CITY OF ALBUQUERQUE

**RE: Valle Vista ES Bus Lane- 1700 Mae Ave. SW
Grading and Drainage Plan
Engineer's Stamp Date 10-16-2014 (File: K12D027)**

RE: **Valle Vista ES Bus Lane- 1700 Mae Ave. SW**
Grading and Drainage Plan
Engineer's Stamp Date 9-22-2014 (File: K12D027)

Based upon the information provided in your submittal received 9-23-14, the above referenced Plan cannot be approved for Grading Permit, Paving Permit, and SO-19 Permit until the following comments are addressed:

BUS LANE IMPROVEMENTS VALLE VISTA ELEMENTARY SCHOOL

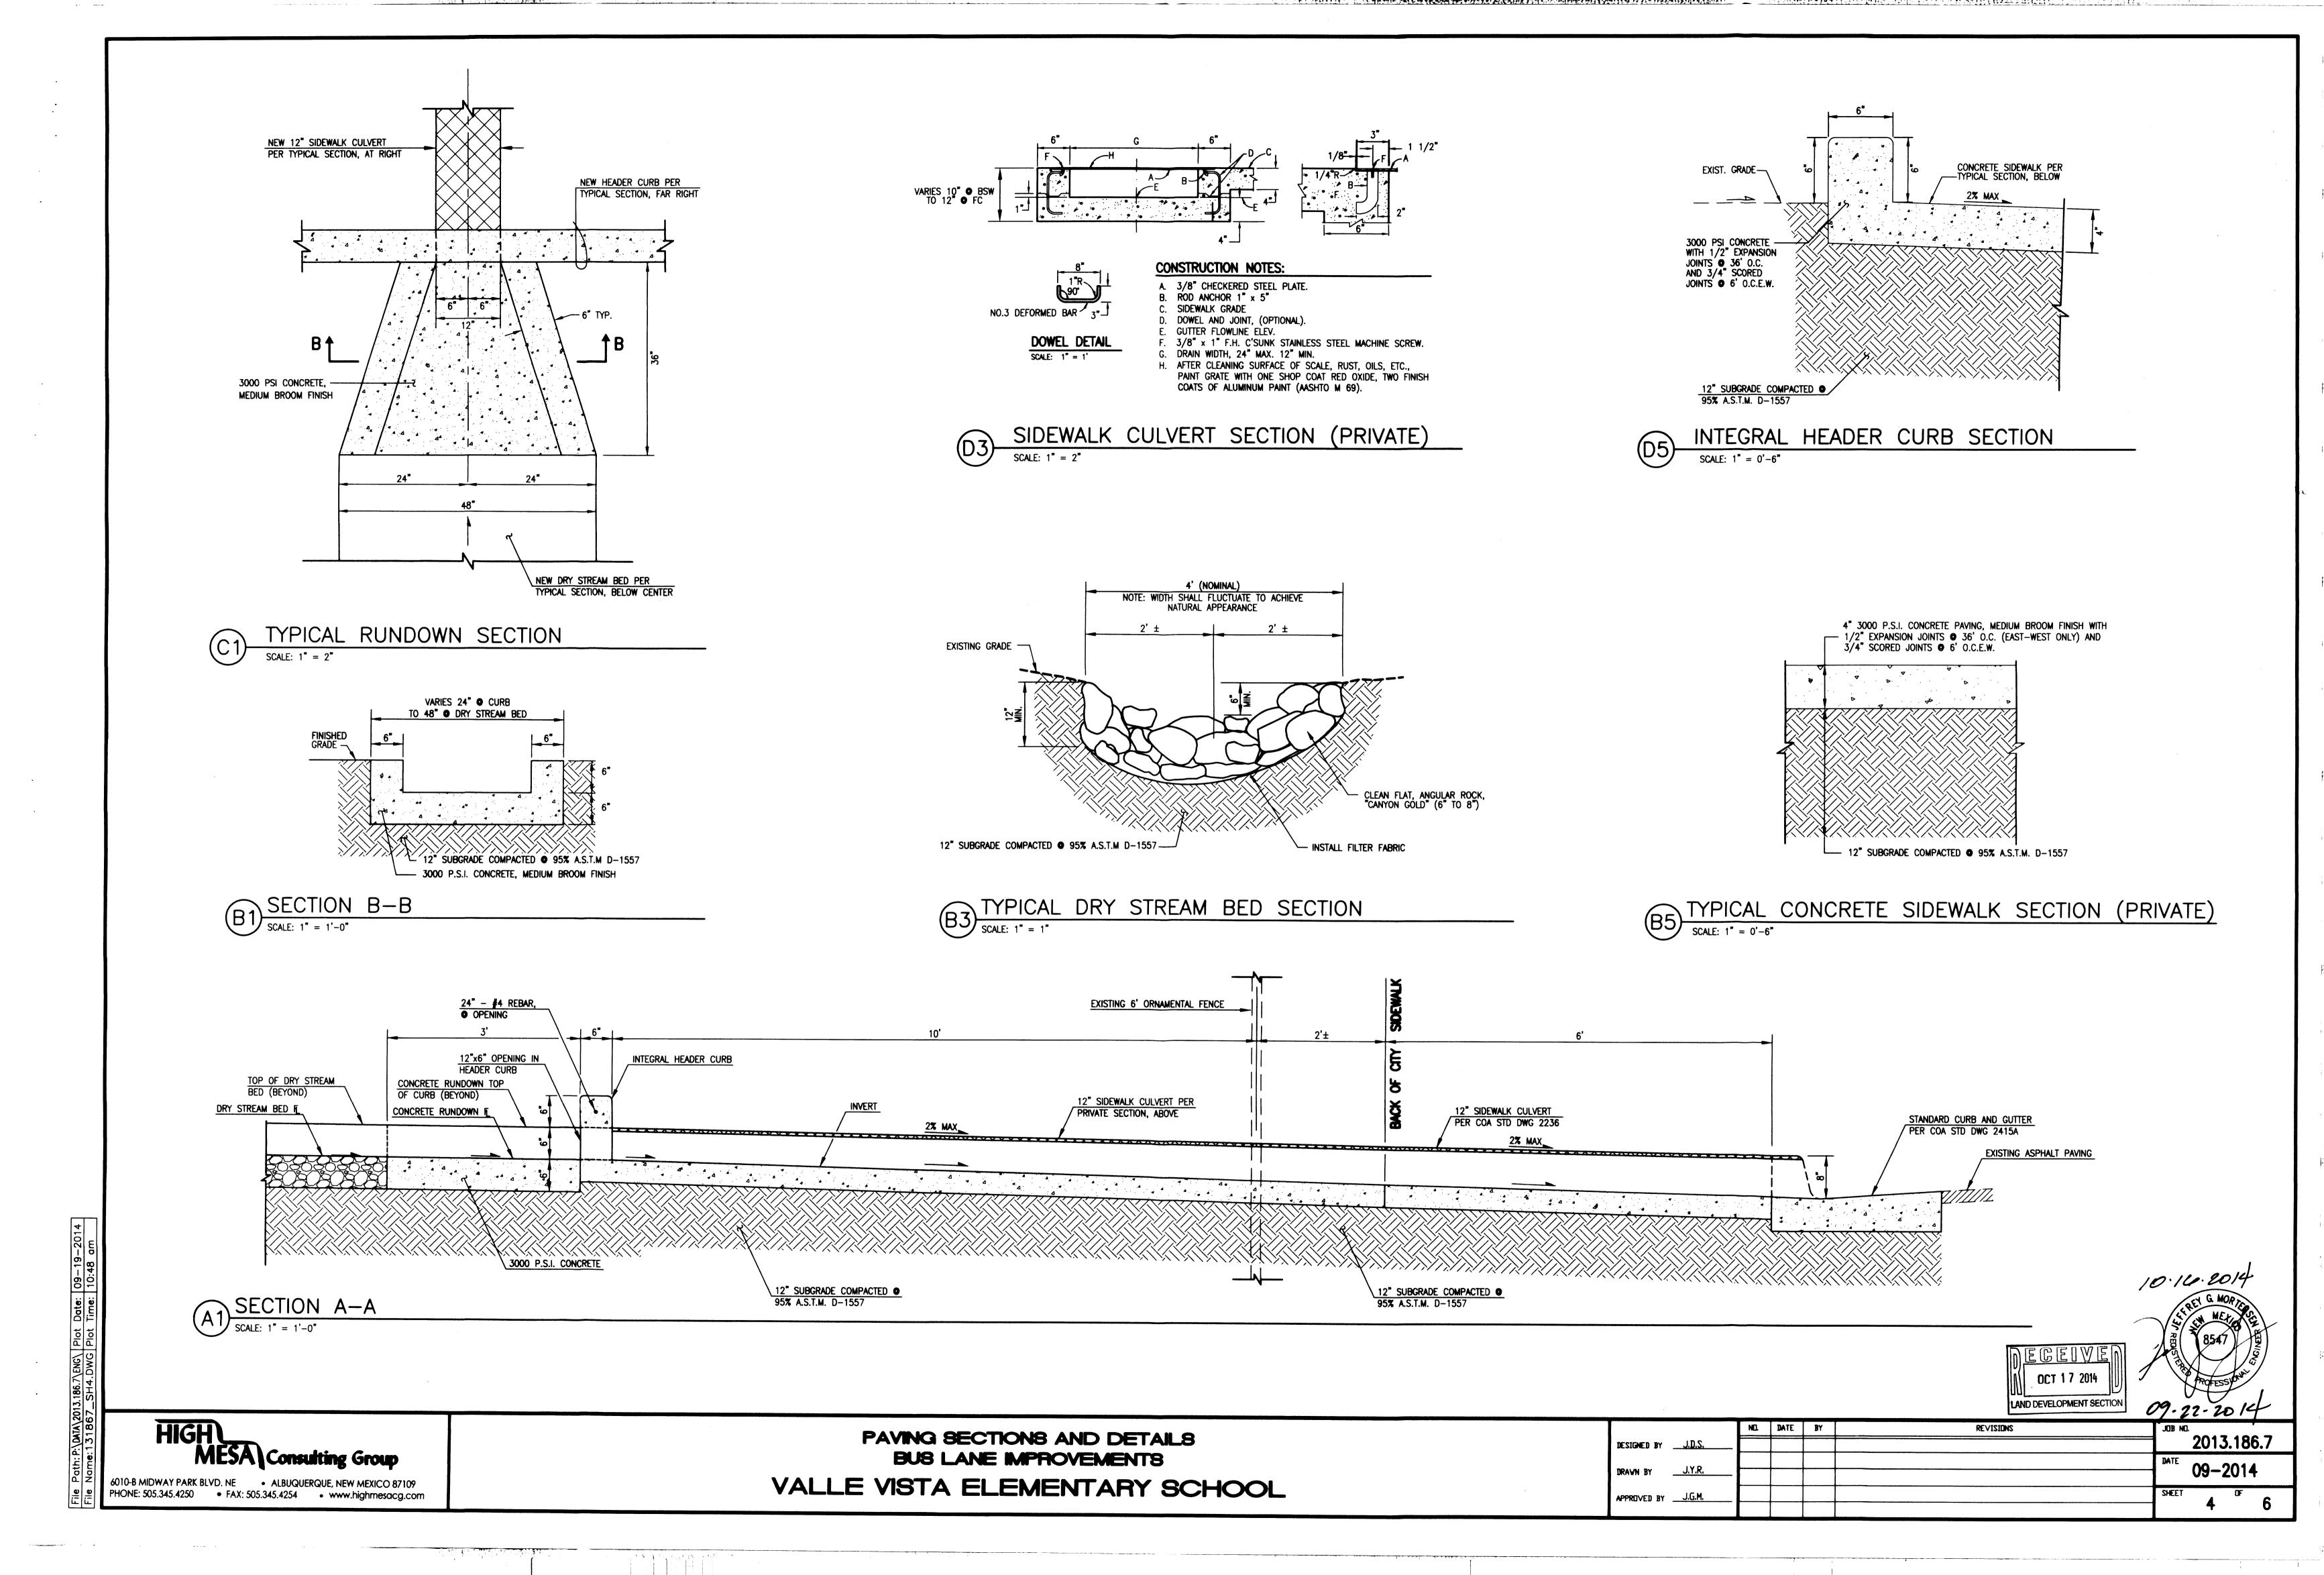
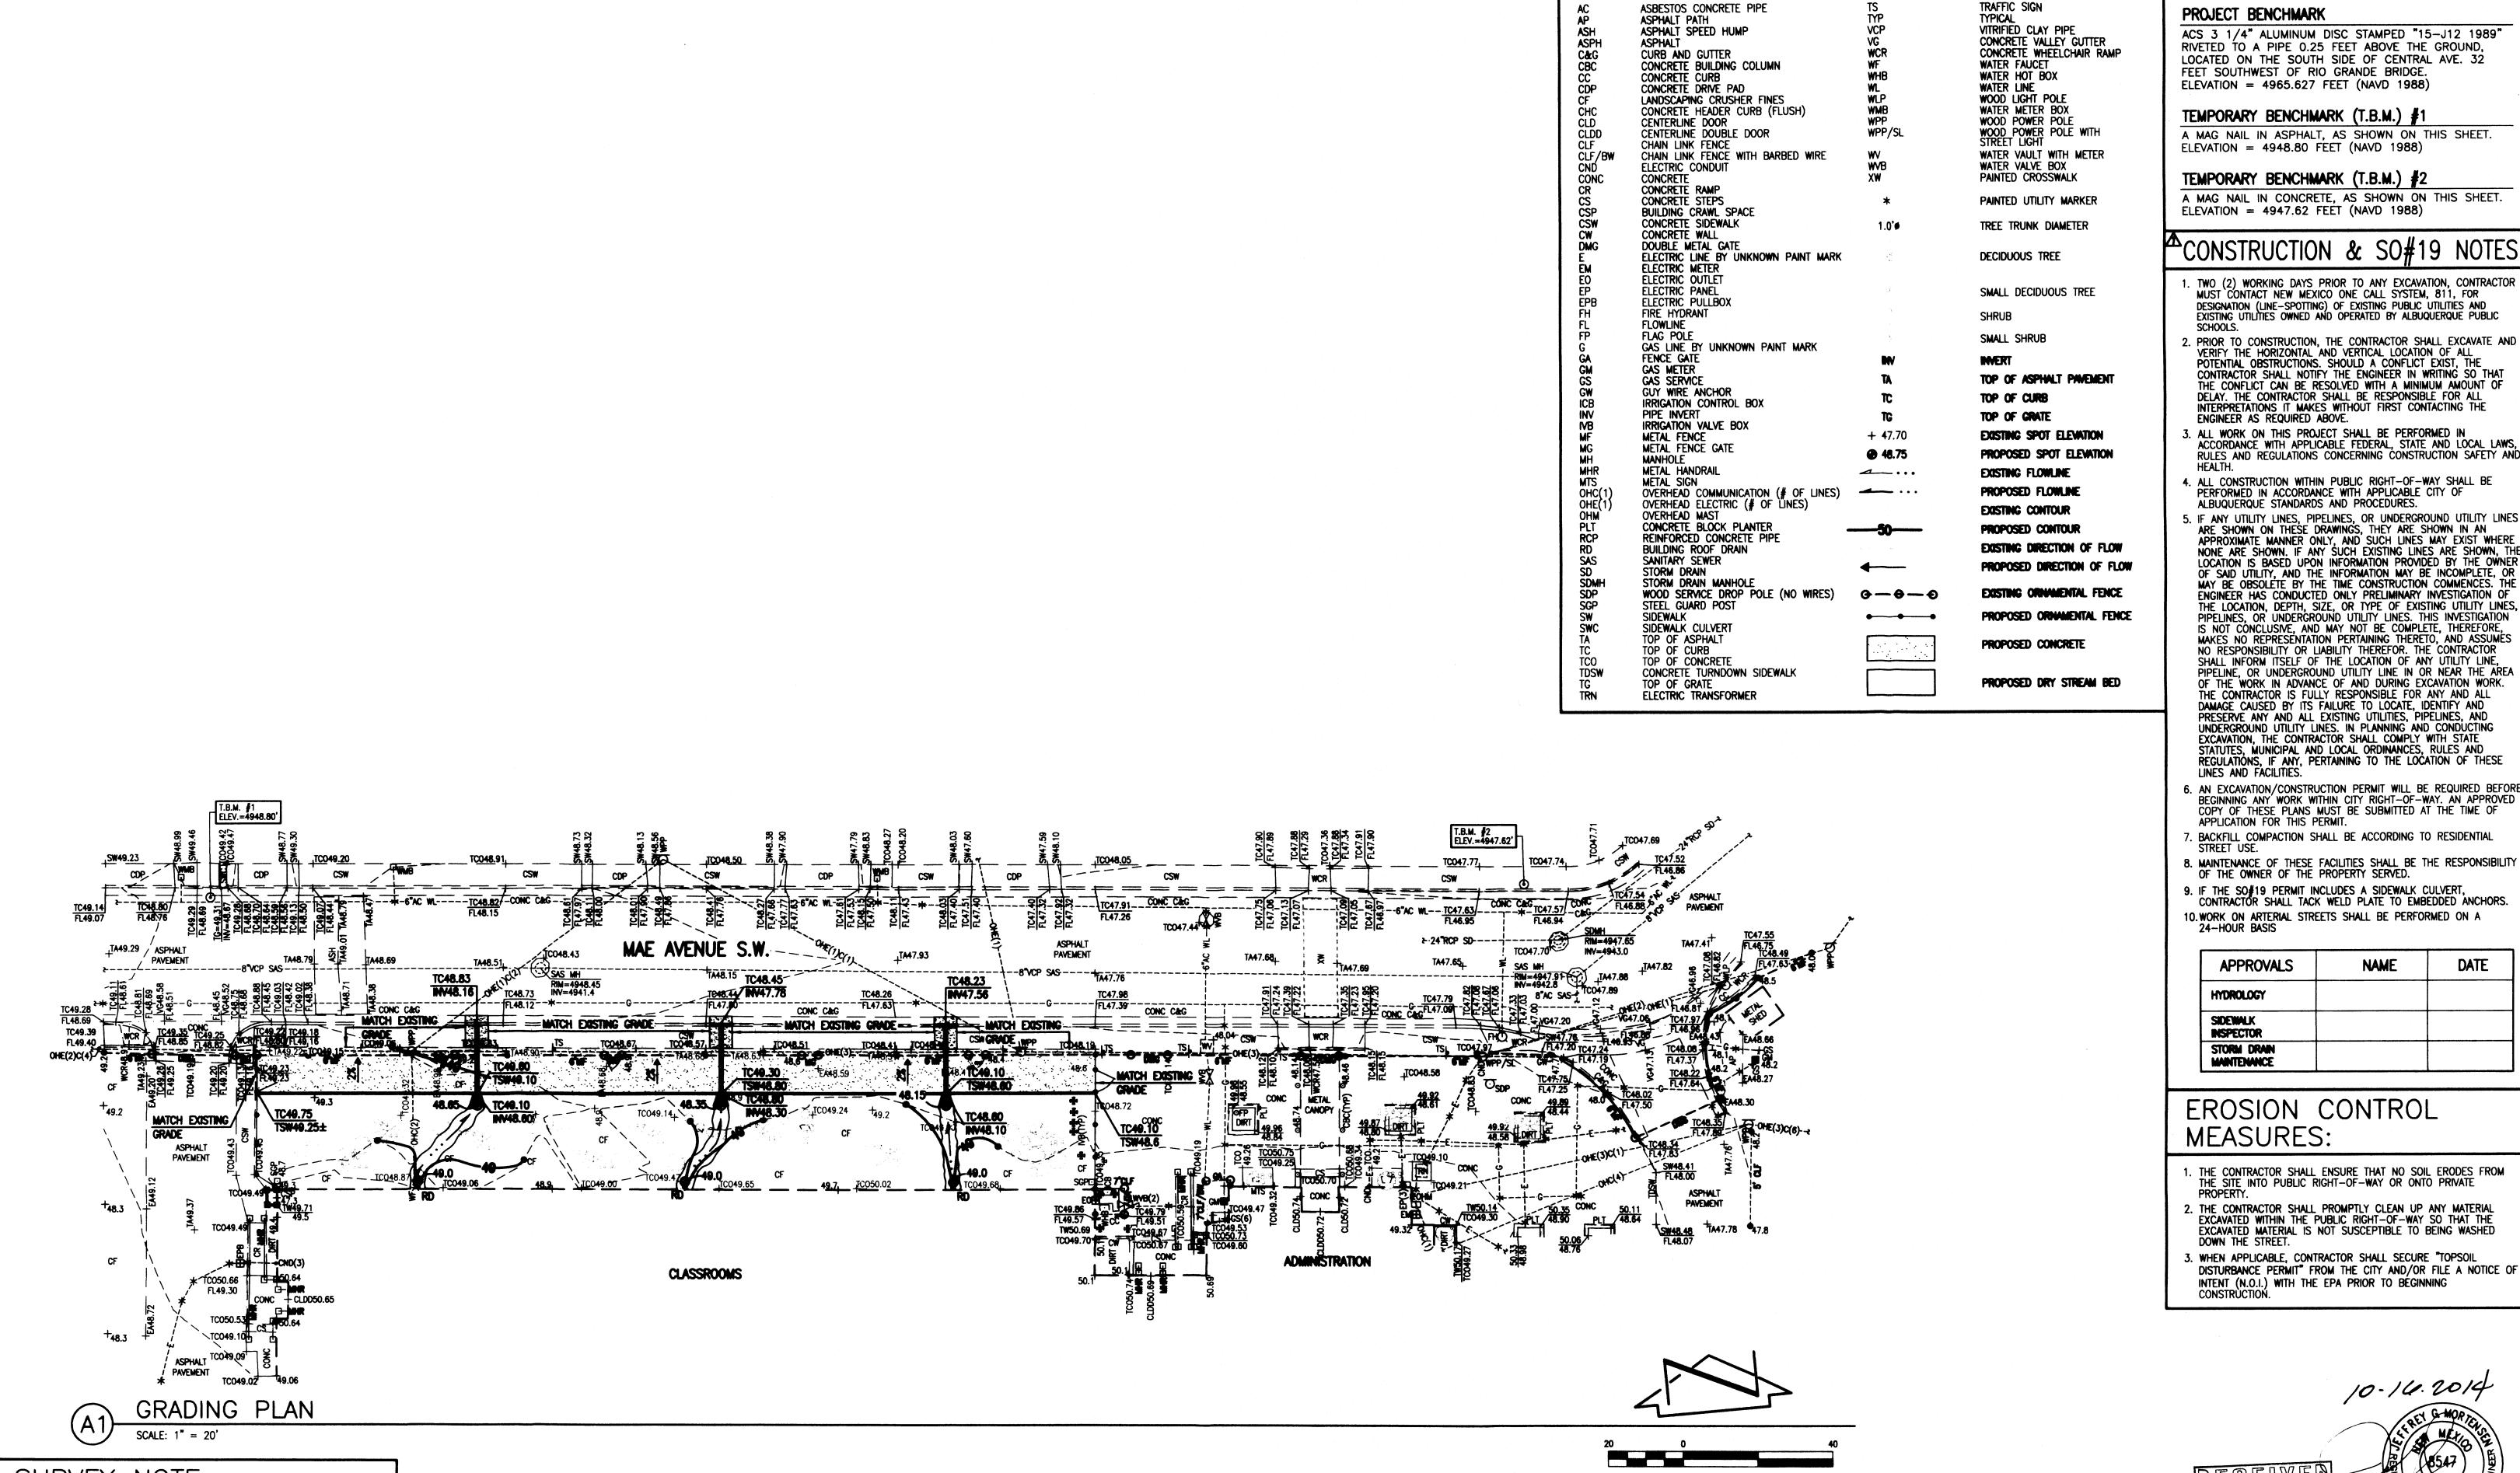
- ✓ 1) In the Project Description, state that project lies within SFHA AH and state the BFE.
- ✓ 2) Obtain a Floodplain Permit for construction within the Flood Plain.
- ✓ 3) Note that the grate on the sidewalk culverts must be tack welded to the embedded anchors. *SO-19 NOTE #9*
- ✓ 4) The Standard SO-19 Construction Notes are attached. In particular, the title needs to be changed and note 6 needs to be added. The signature block should remain.
- 5) The SO-19 approval is for the Sidewalk culverts only. The curb painting is not a part of this approval.
